CITY OF ALBUQUERQUE  
ADMINISTRATIVE APPROVAL (AA)- SITE DEV PLAN AMENDMENT  
ROUTING & REVIEW SHEET

APPLICATION #: 14AA-10038	PROJECT #: <del>100</del> 1010075
PROJECT NAME: Frito Lay - Renaissance	
APPLICANT or AGENT: Tierra West - John Nrslei	
PHONE # and E-MAIL: 858-3100	
ZONE ATLAS PAGE: F-16	
ADMINISTRATIVE APPROVAL (AA) for:	<input type="checkbox"/> EPC CASE <input checked="" type="checkbox"/> DRB CASE

**RE: ADMINISTRATIVE AMENDMENT  
TR 9 AIA PLAT OF TRS 9AIA & 9A1B RENNAISSANCE CENTER  
ZONE MAP F-16**

**Project # 1010075      Administrative Amendment Request**

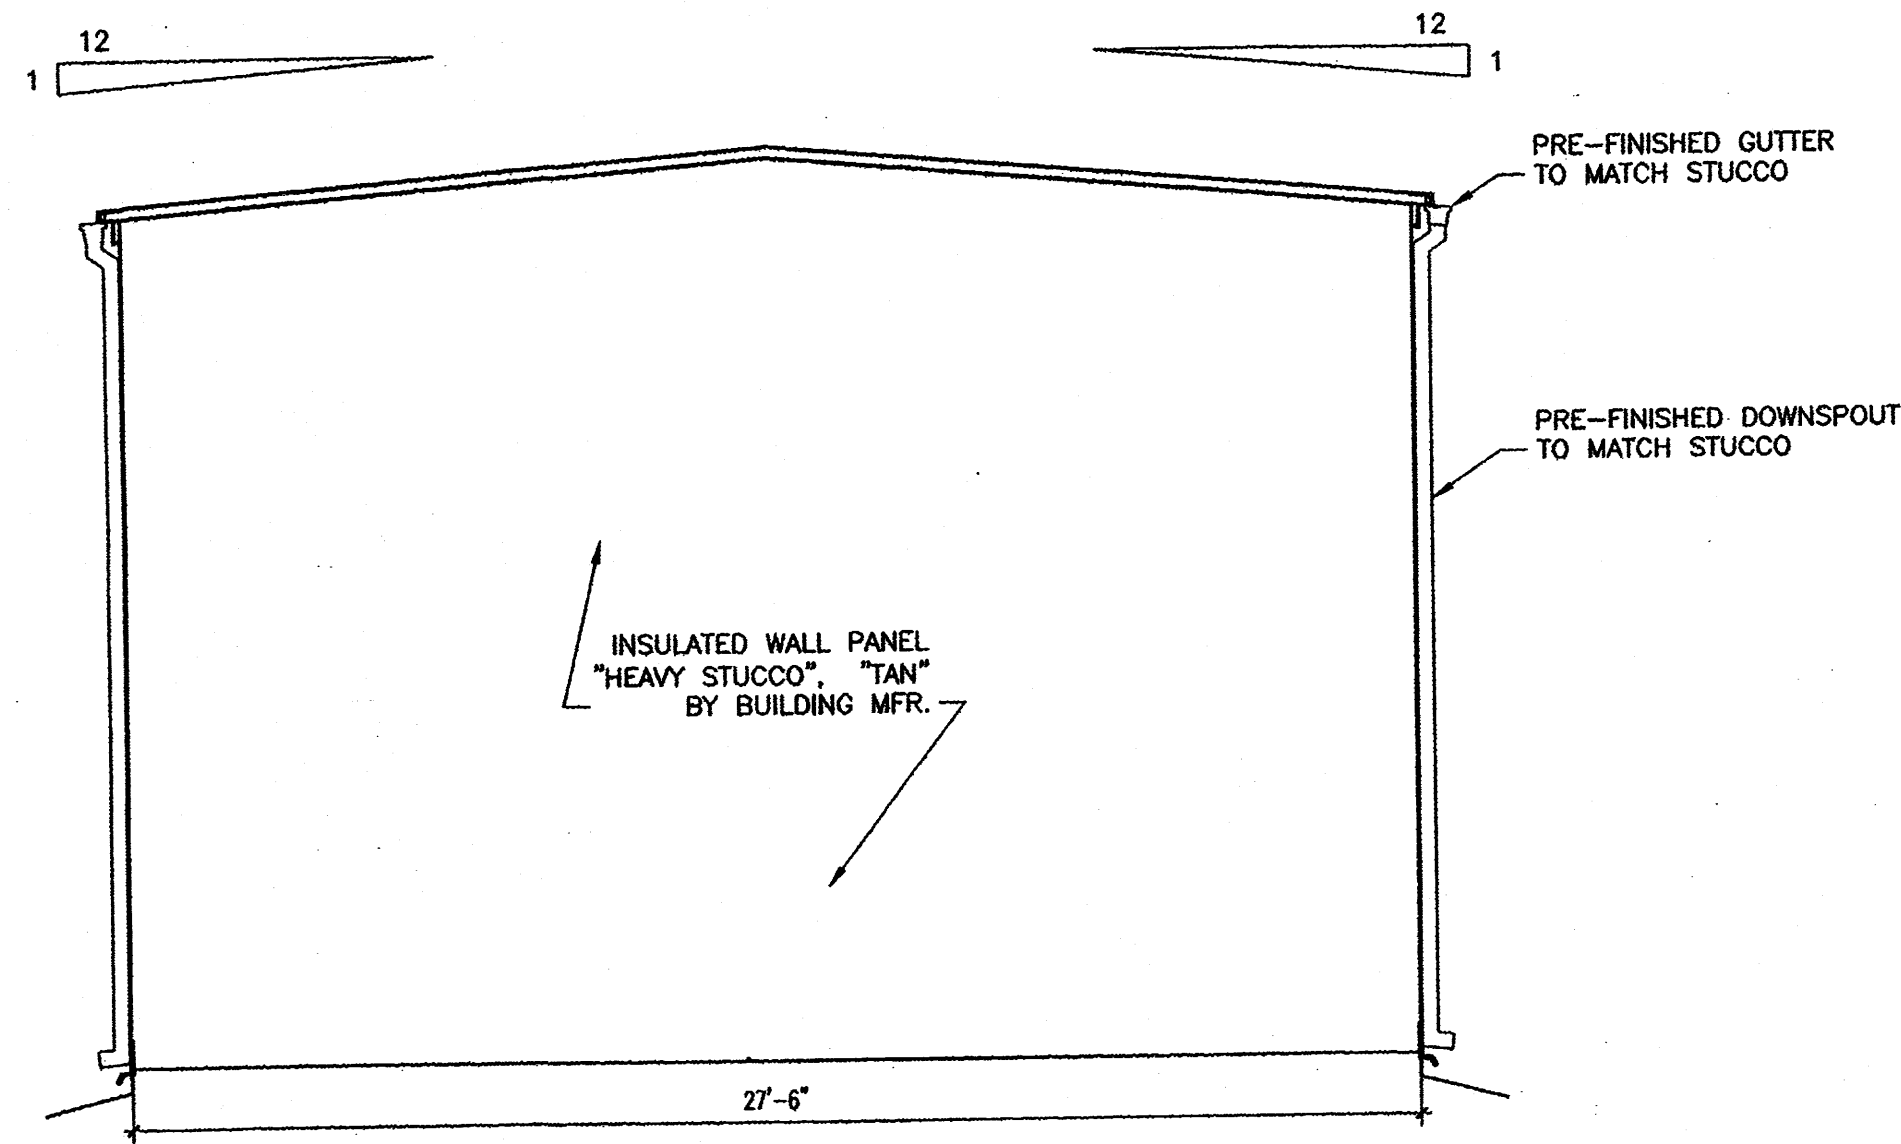
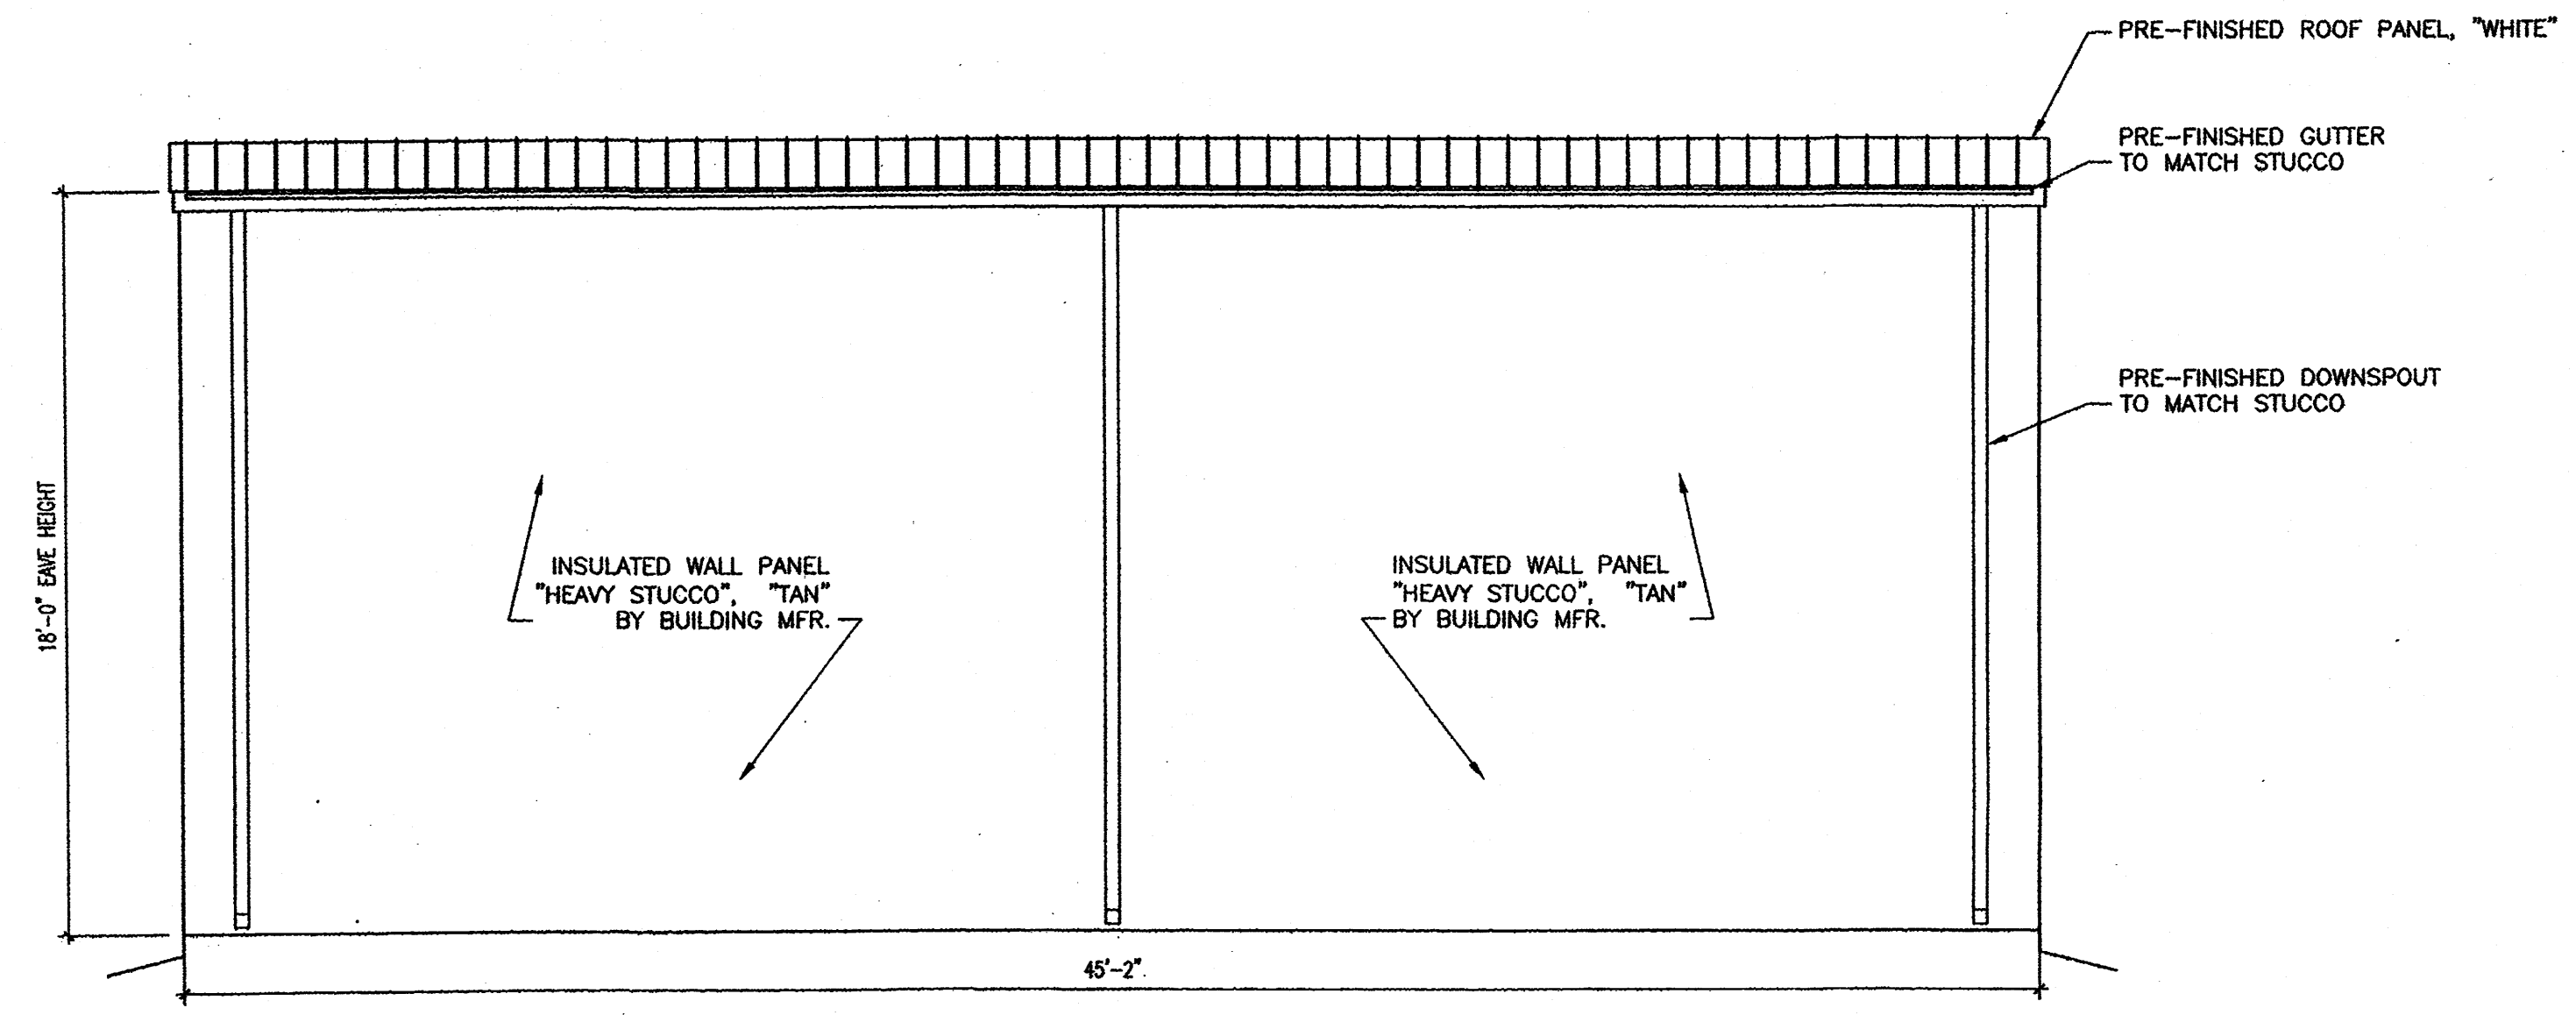
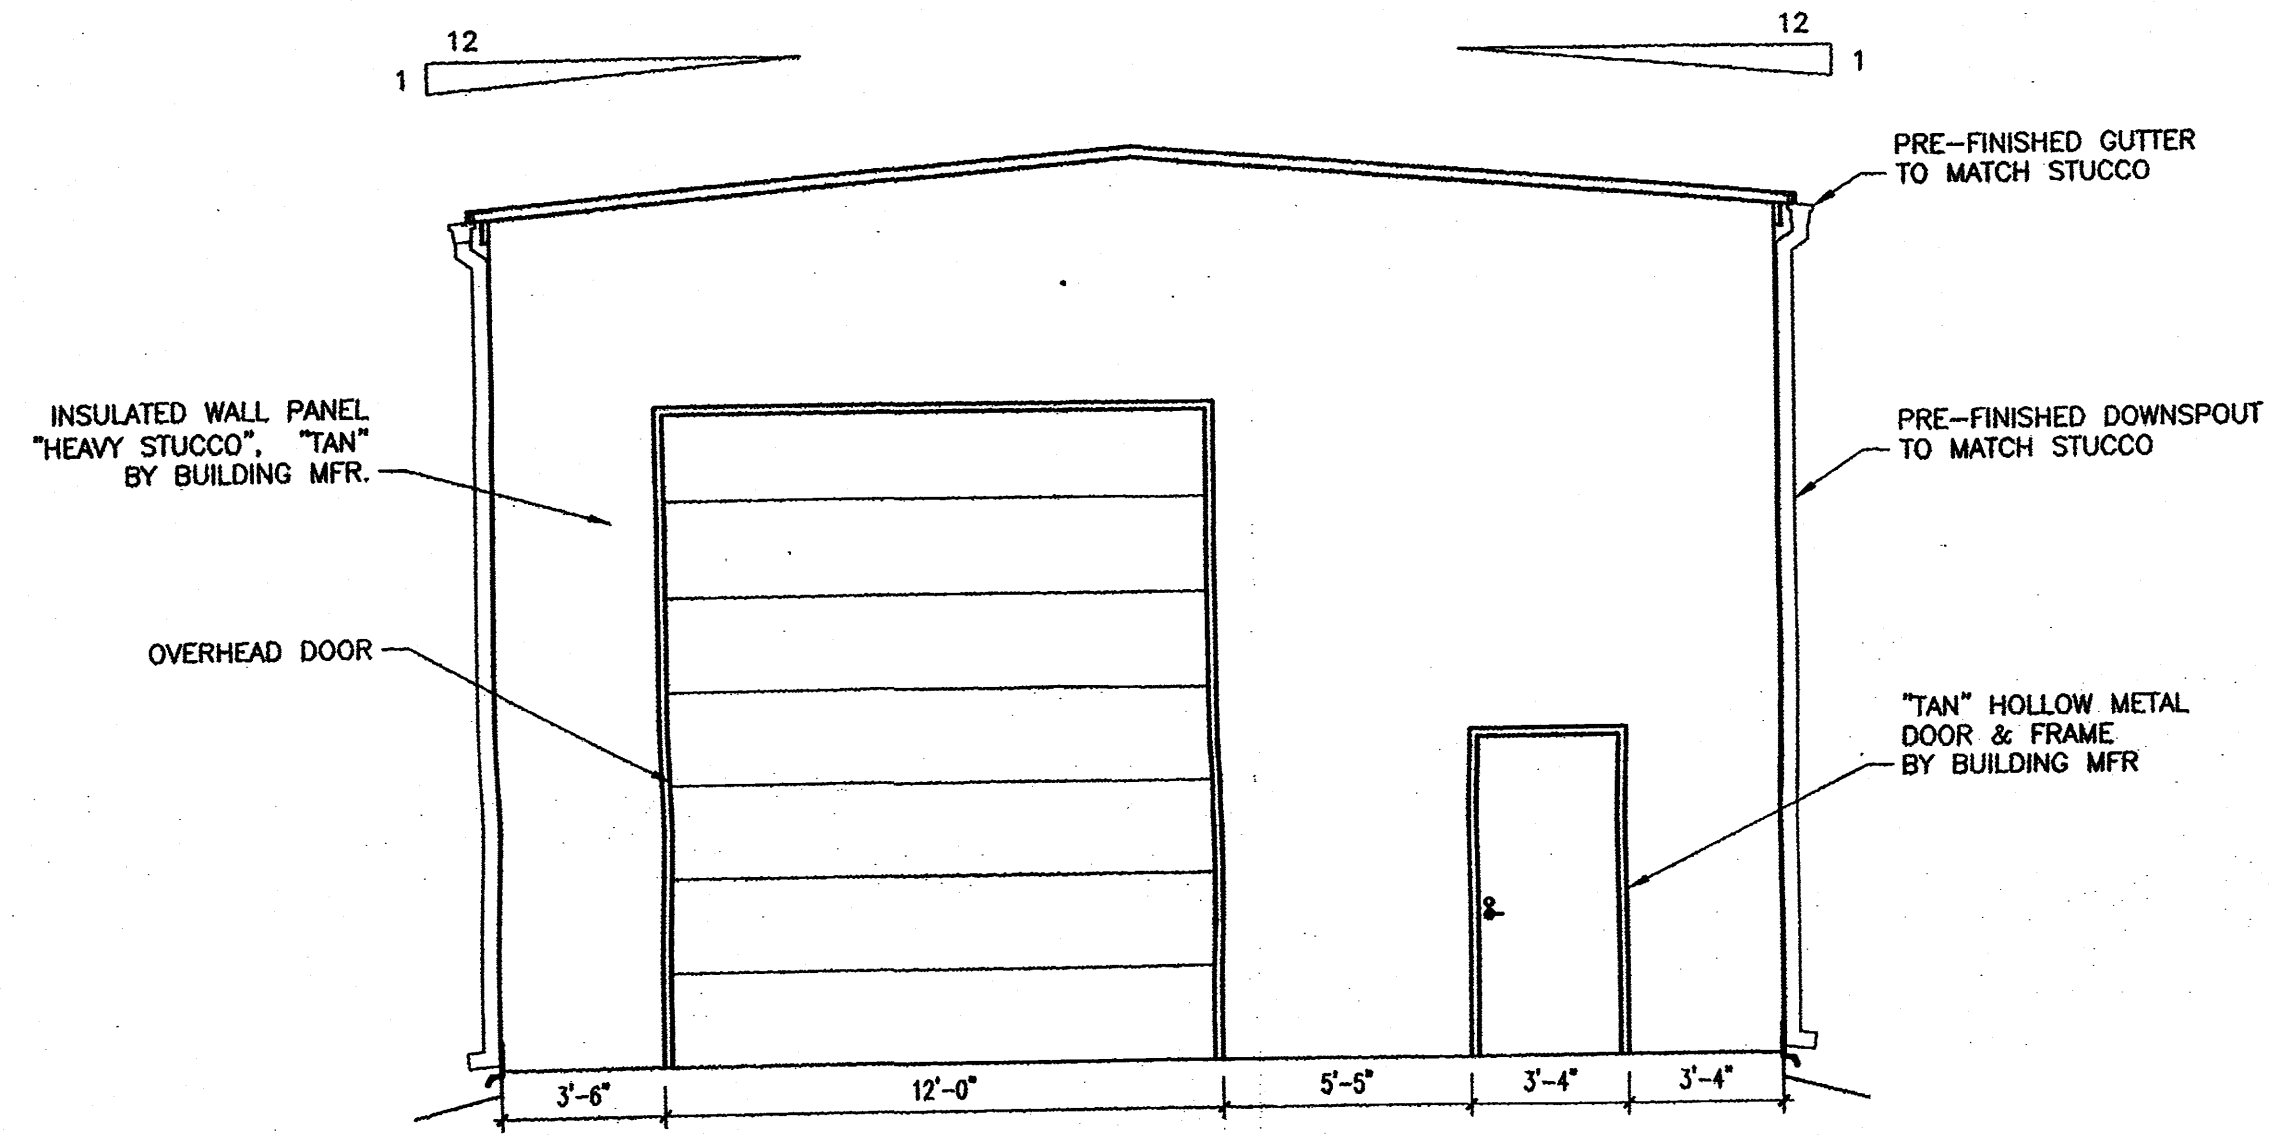
CURRENT PLANNING	DATE RECEIVED: 5-2-14
APPLICATION COMPLETE:	DATE: 5-2-14
APPLICATION INCOMPLETE:	DATE:
ROUTING NEEDED:	<input type="checkbox"/> YES <input checked="" type="checkbox"/> NO
COMMENTS:	
<p>① complete - may want more detail on elevations (eral using Renaissance master plan standards) (cl)</p> <p>② site looks non-compliant with existing approved site plan - esp landscaping - see aerial photo.</p>
